# ROAD SAFETY AUDIT RESPONSE REPORT – Rev A

**August 2015**

Location:	Southam Road, Banbury	Scheme:	Supermarket Development
Drawing numbers:	26004/2001/001	Project number:	26004
Site visit:	Yes Date: 02-12-14	Weather:	Cold with light rain fall

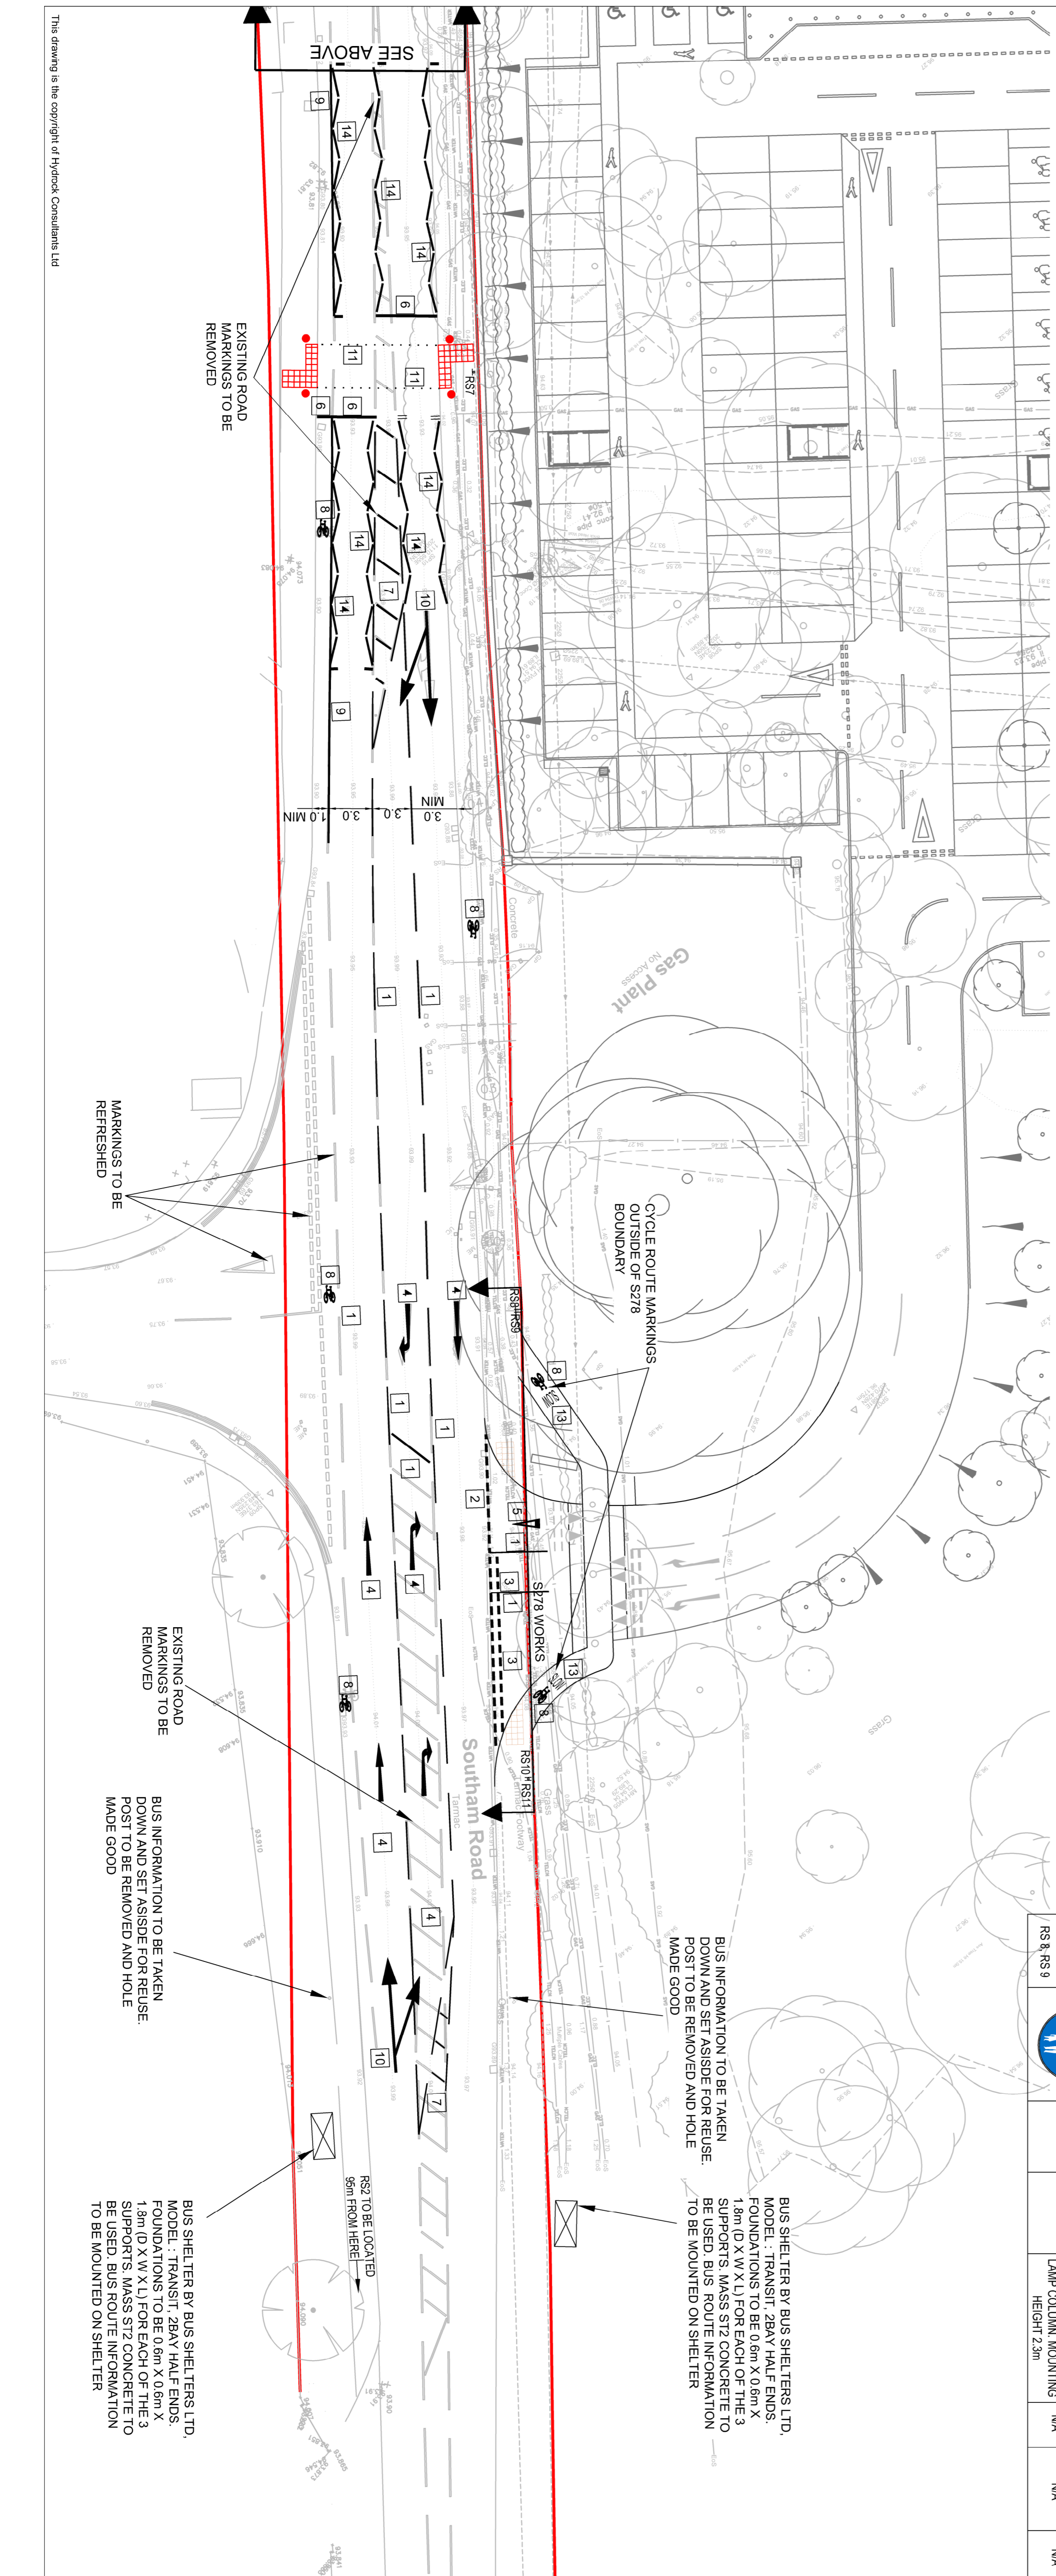
2.5	<p><b>Summary - Vulnerable pedestrians in danger of being struck by other road users</b></p> <p>Stage 1 RSA Recommendation</p>

<p>Uncontrolled crossing points should be provided inset into the minor roads. If possible, the corner radii forming the junctions should be reduced in order to locate these crossing points closer to the direct NMU desire line.</p> <p>Appropriate tactile paving should also be provided as part of the details of the pedestrian ramp and steps between Southam Road and the car park.</p>	<p><b>Tactile paving details will be included on the construction details that will be agreed with OCC through the S278 design submission whereby appropriate crossing details will be provided.</b></p>

2.6	<p><b>Summary - Lack of crossing facilities could result in NMUs being struck by other road users</b></p> <p>Stage 1 RSA Recommendation</p> <p>An assessment (such as LTN 1/95 – ‘The Assessment of Pedestrian Crossings’) should be undertaken to determine the need and appropriate form of crossing facilities required across Southam Road. Following this assessment, the proposed junctions should be amended to accommodate the outcome of this assessment if necessary. Any proposed crossing provisions should consider and accommodate the existing bus stops located to the north of the proposed Car Park junction, as well as the Public Right of Way on the south side of the proposed Service Access</p>	<p><b>Since submission of the TA (May 2015) further consultation has been undertaken with OCC relating to the provision of pedestrian crossing facilities on Southam Road, It is proposed to provide a zebra pedestrian crossing on Southam Road in proximity to the proposed food store to enhance connectivity to nearby retail facilities as well as public transport services.</b></p> <p><b>The design and location of the Zebra crossing will be agreed with OCC through the S278 design submission.</b></p>
